Appendix C Consultation

C.3 Agency engagement

C.3.1 Transport for NSW email chain

Subject: RE: Akaysha Energy Orana BESS Project, Wellington - TIA and Access Discussion

Orana Battery Energy Storage System

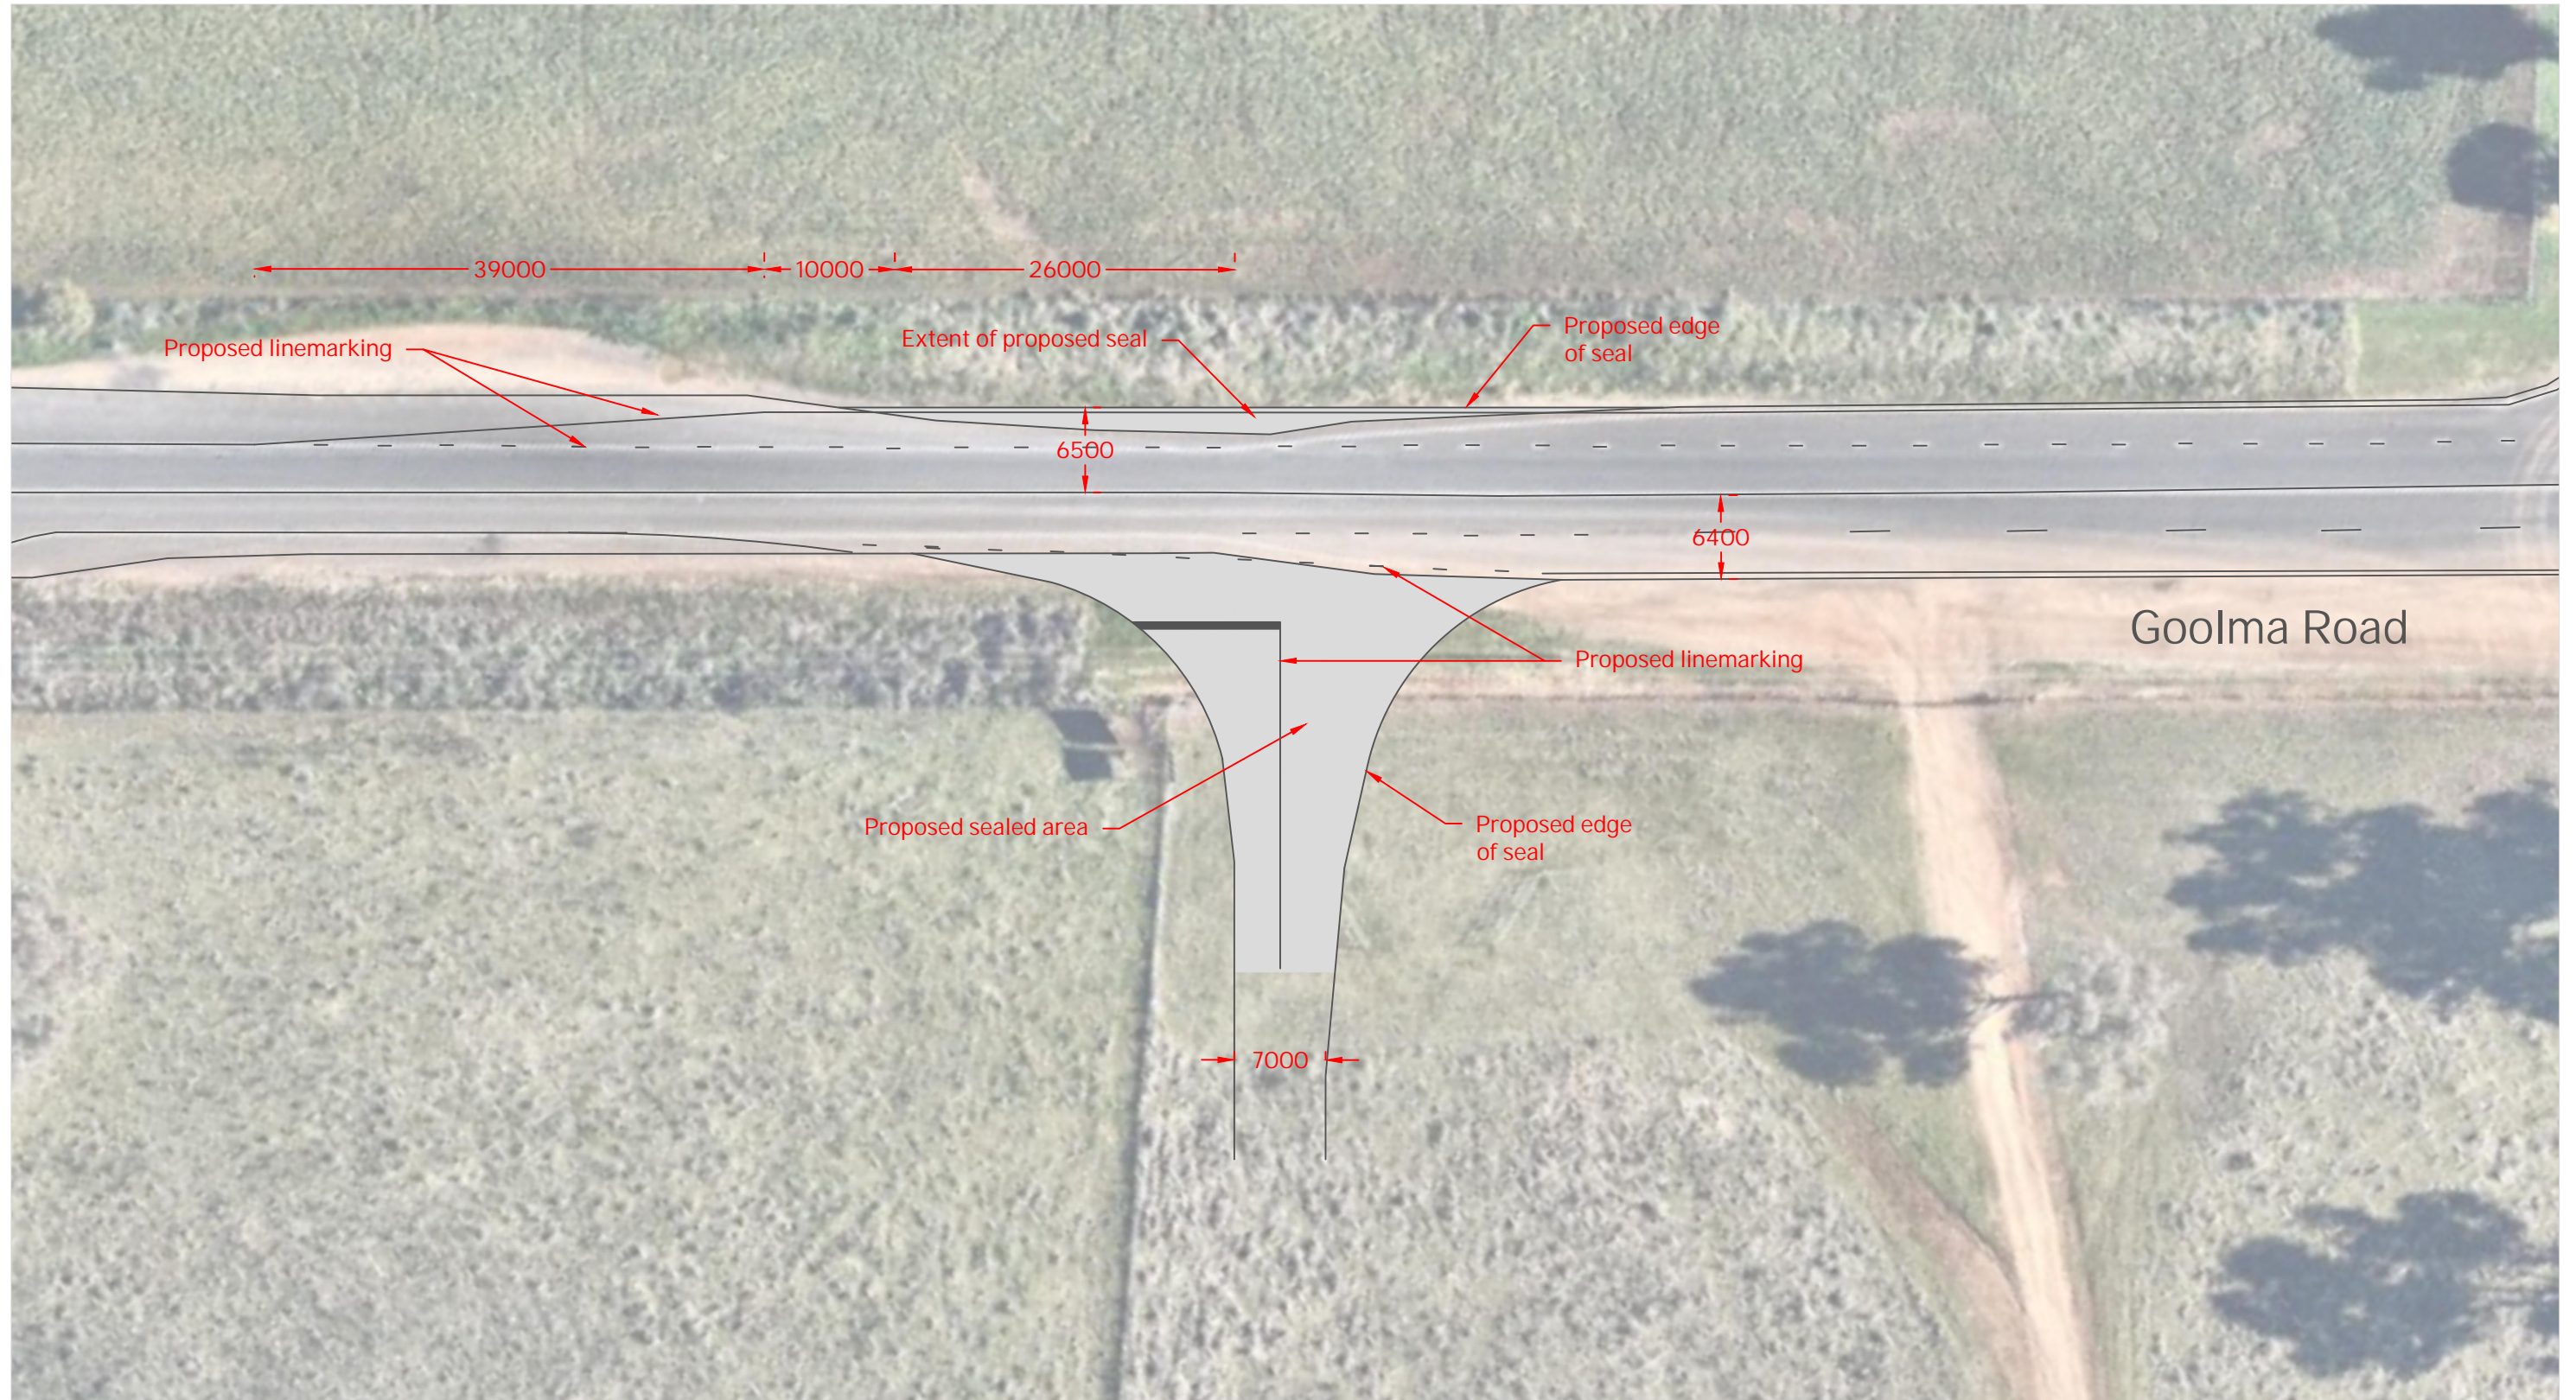
- The strategic design provided does not represent the BAL/CHR(S). *Amber state it does represent the BAL/CHR(S), as verified by the dimensions on the plans for these turn treatments.*

Orana Battery Energy Storage System
 6945 Goolma Road, Wuuluman
 Swept Path Assessment

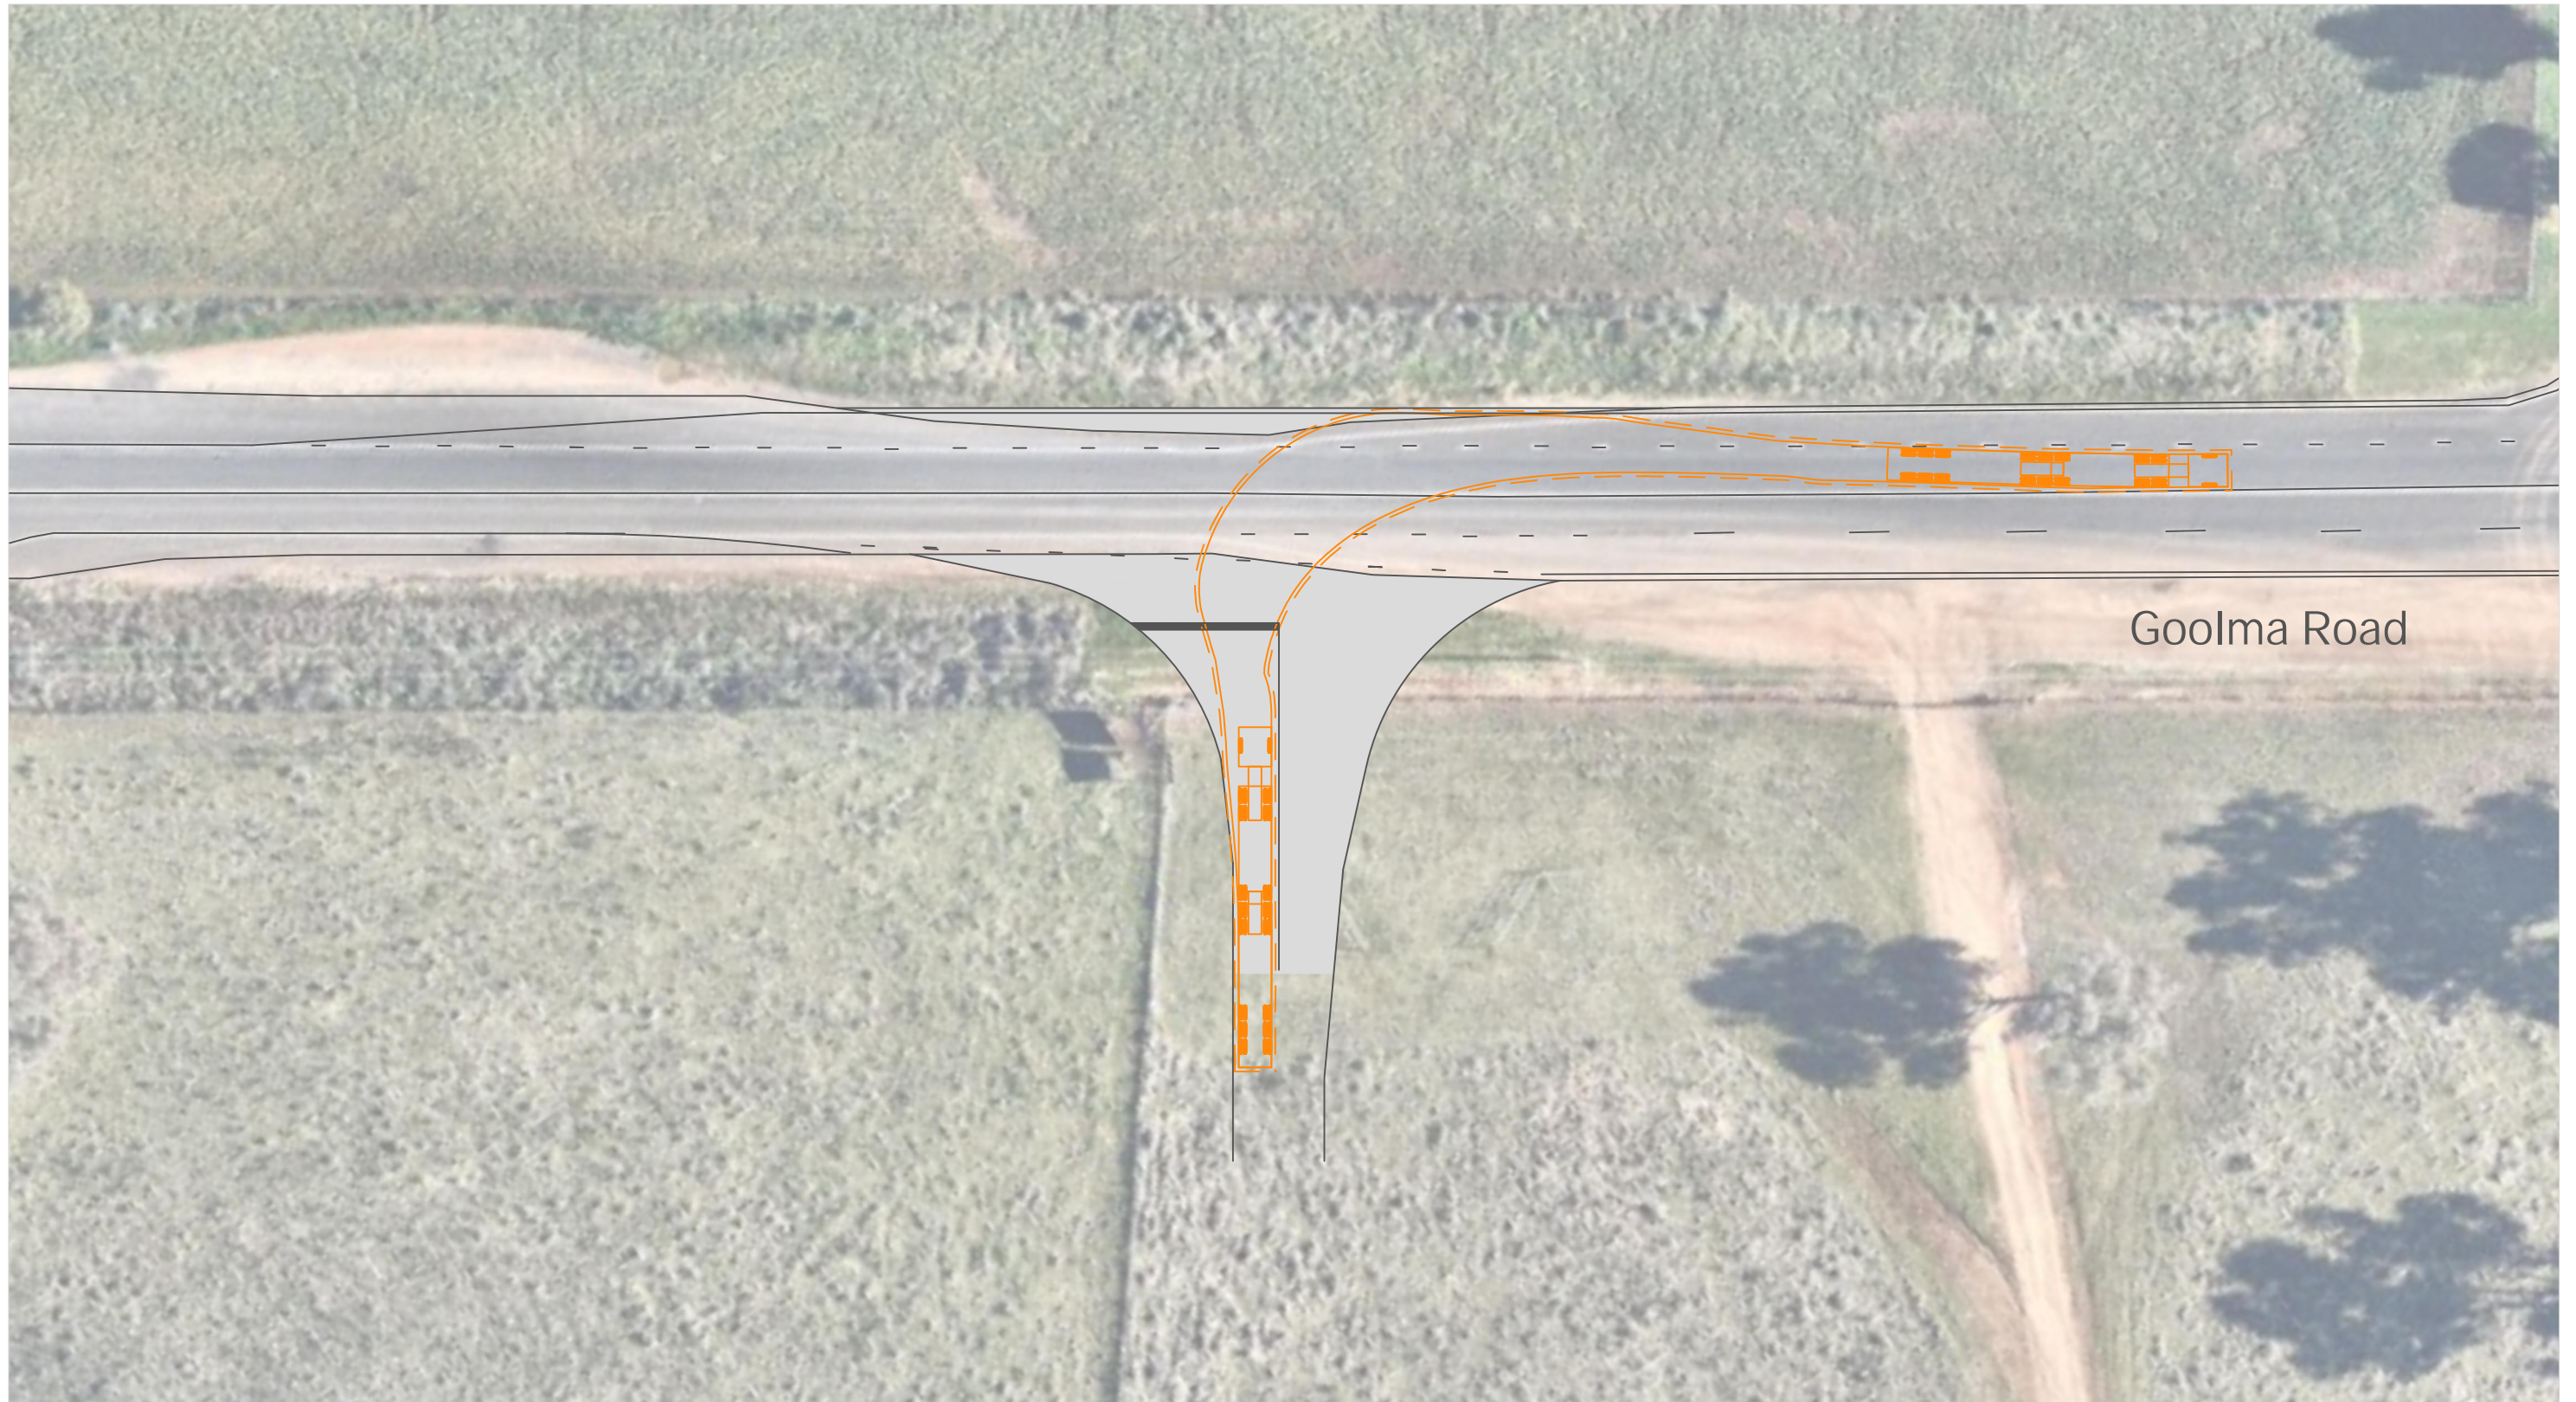
- The last swept path identifies that the B-double design vehicle turning right will require to utilise the through lane and the BAL to turn right. *Noted.*

17. The last swept path identifies that the B-double design vehicle turning right will require to utilise the through lane and the BAL to turn right.
